From: Martyn White <Martyn.White@arun.gov.uk>
Sent: 06 December 2019 14:19
To: Amber Willard <Amber.Willard@arun.gov.uk>
Cc: Planning.Responses <Planning.Responses@arun.gov.uk>
Subject: BR/237/19/PL & BR/238/19/L

BR/237/19/PL & BR/238/19/L

The Cinema is an attractive building which has been identified as Grade II Listed. It is also located within the Station Square Conservation Area. Other buildings within the conservation area are either listed or locally listed Buildings or Structures of Character which collectively form an imposing group of late Victorian and Edwardian buildings.

PART OF GROUND FLOOR PLAN

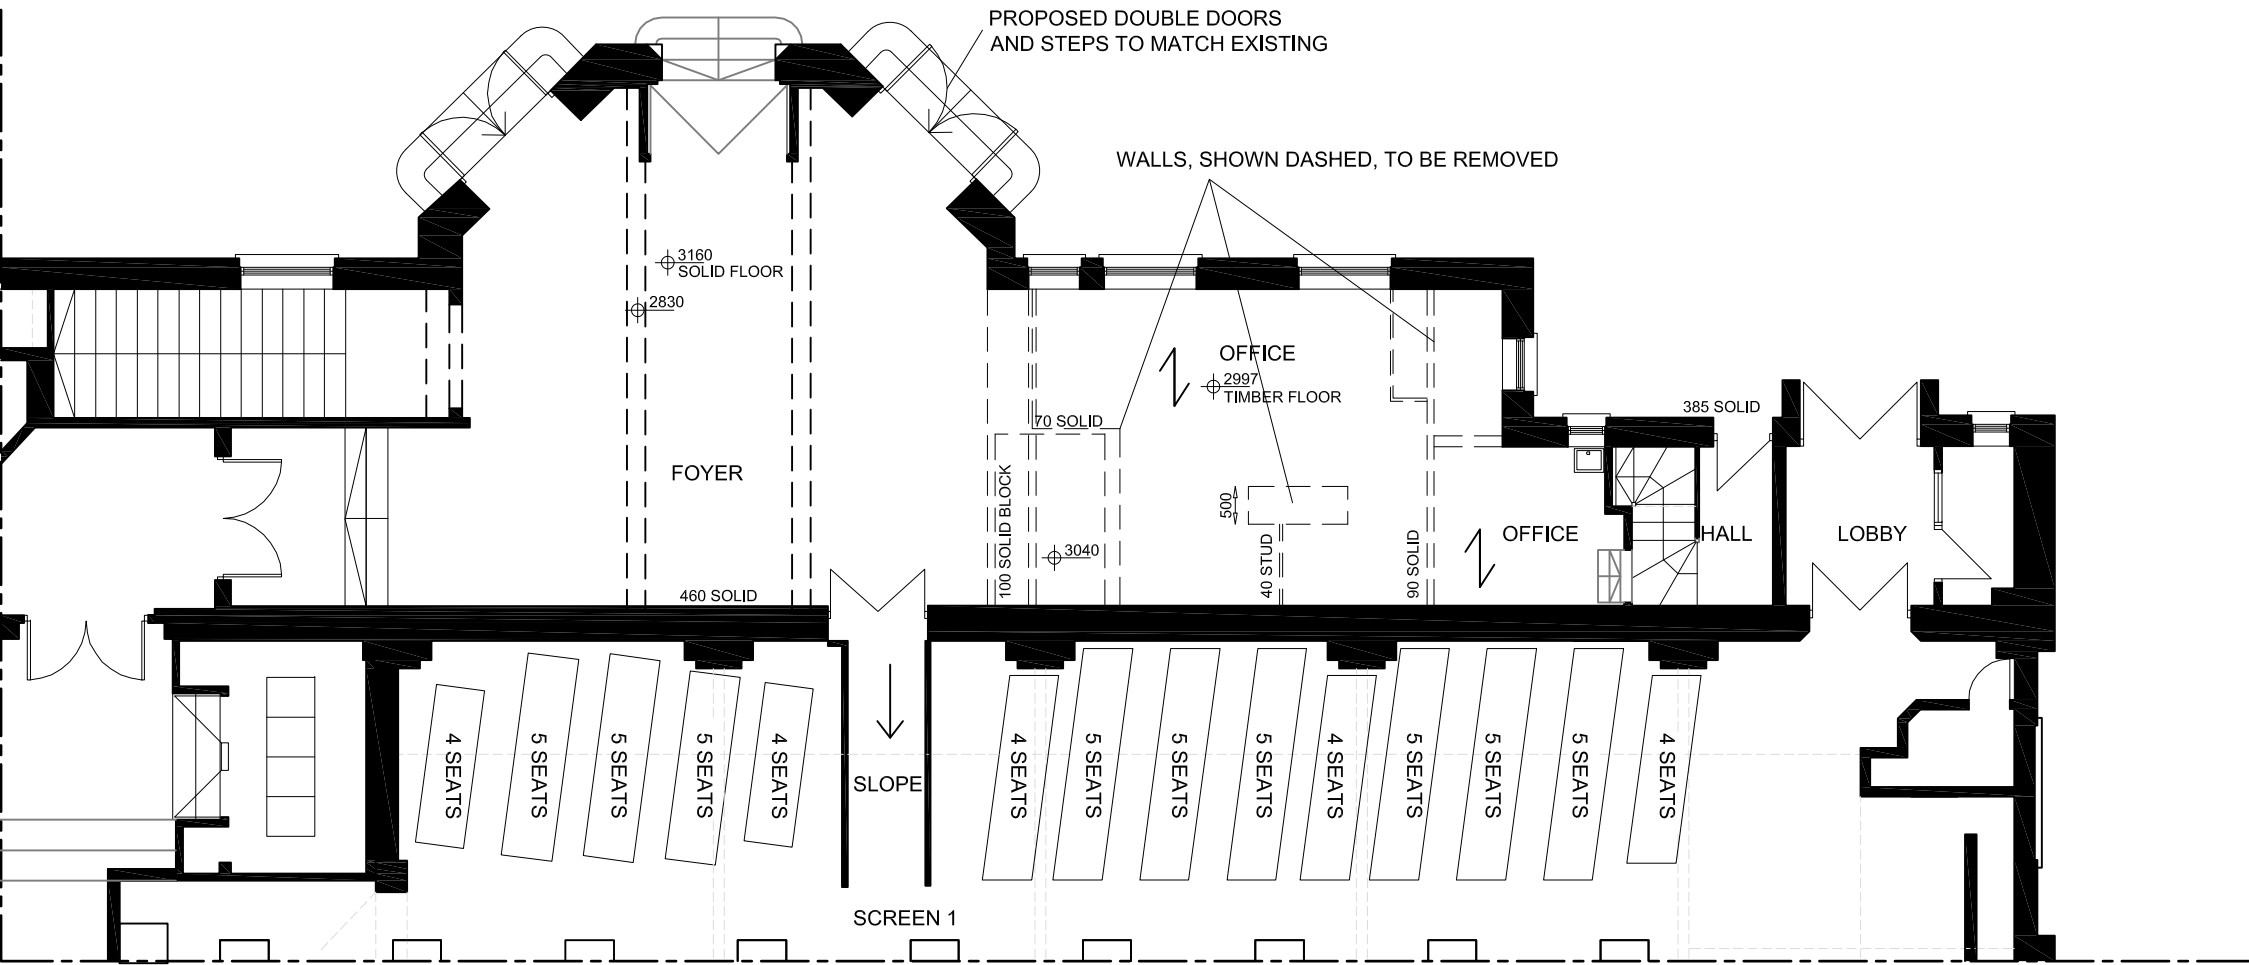
The issue of the removal of the internal walls is much more problematic in that the original layout of the building is considered to be fairly original in the assessment undertaken when the building was listed. It appears that that intention is to remove these walls to open up the foyer area on the ground floor, and office space on the first floor.

It is considered that the loss of these walls on the ground floor would erode the character of the space, and therefore impact upon the significance of the building. Little information is provided with regards to what the space is to be used for, or if any new structures will be located in it. Without this information, it is hard to justify the loss of the walls/impact upon the building. It might be that an alternative approach could be established which creates the spaces required, whilst protecting this key space within the building.

PART OF FIRST FLOOR PLAN

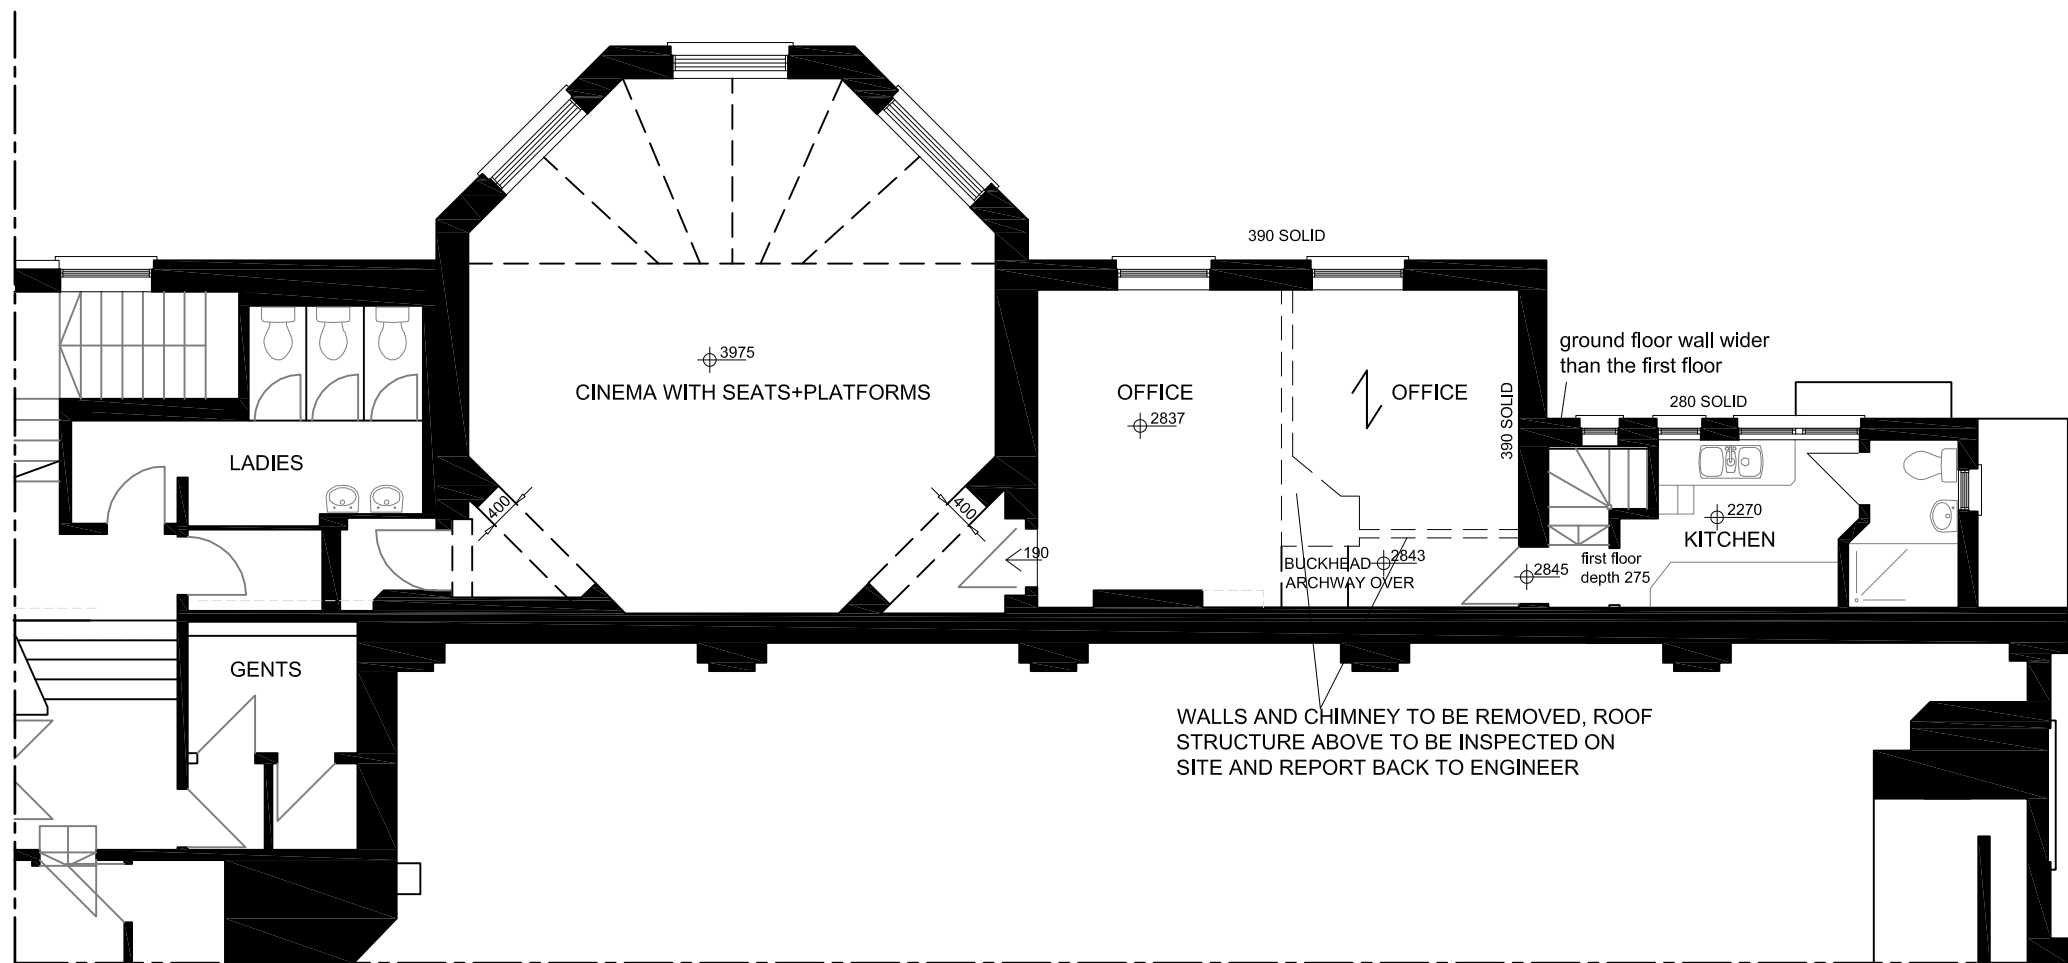
The works on the first floor could be acceptable, subject to the retention of some form of nib in order to indicate where the former layout would have been.

PROPOSED DOOR ELEVATION 1:20

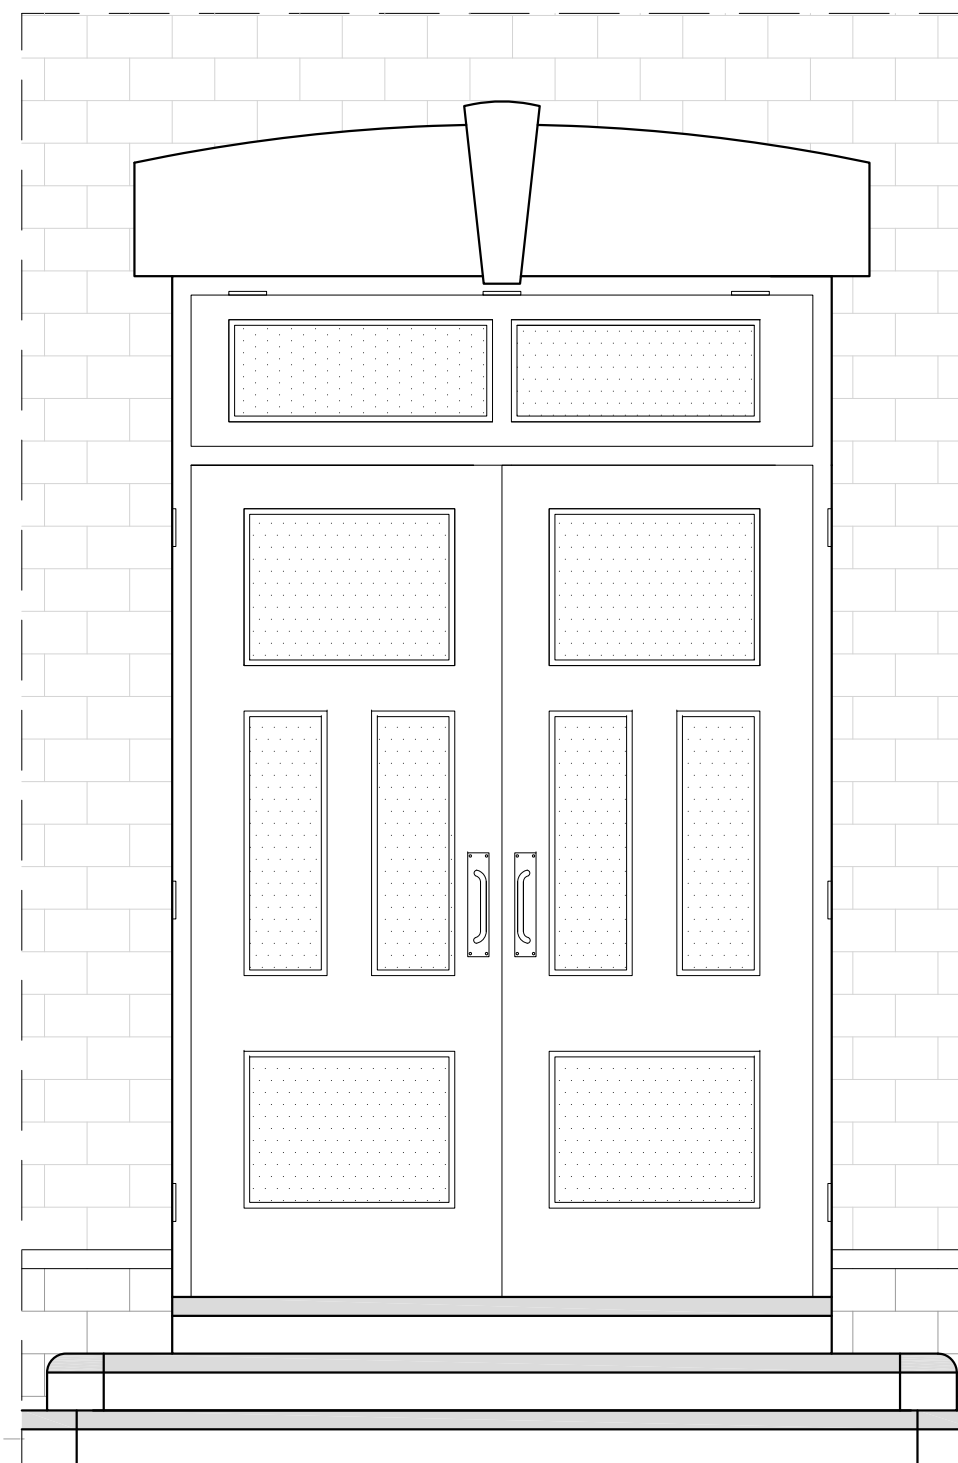
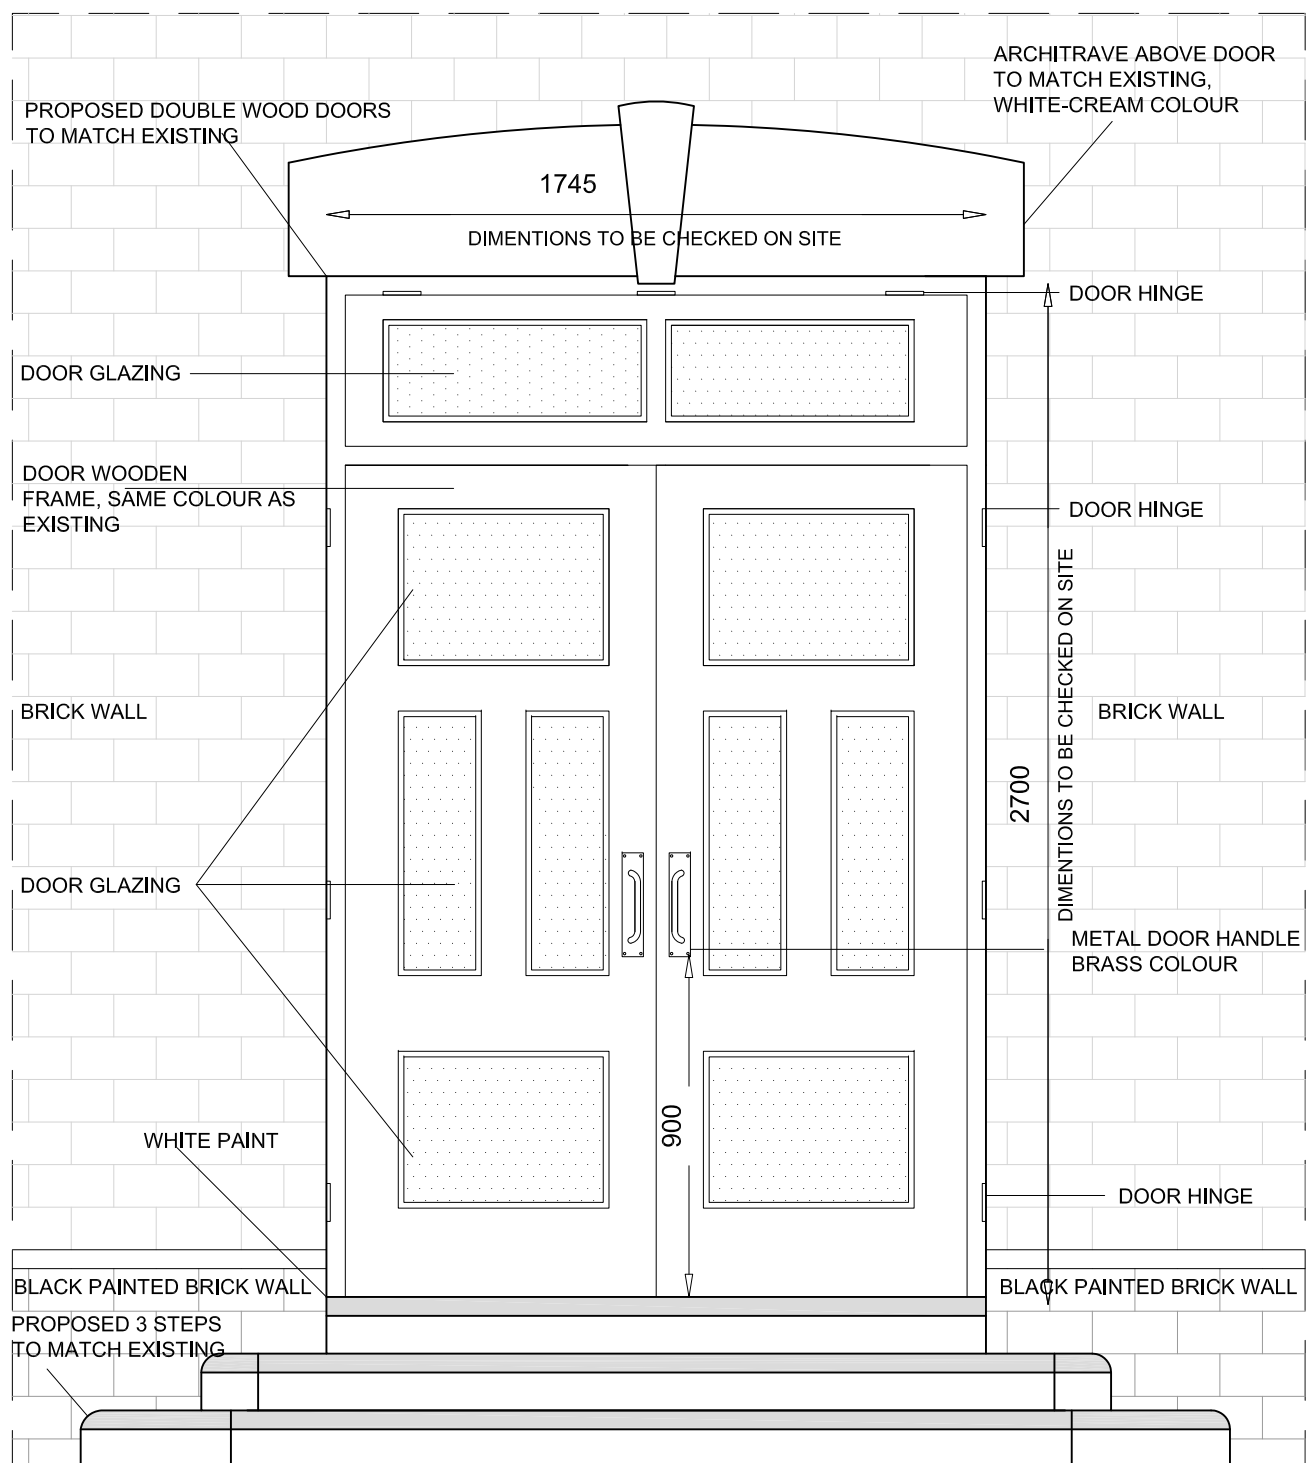
The removal of the window and its replacement with a pair of doors which appear to match the existing other two doors, will have a neutral impact upon the significance of the building. The colour of the doors and the door furniture should also match that of the existing ones.
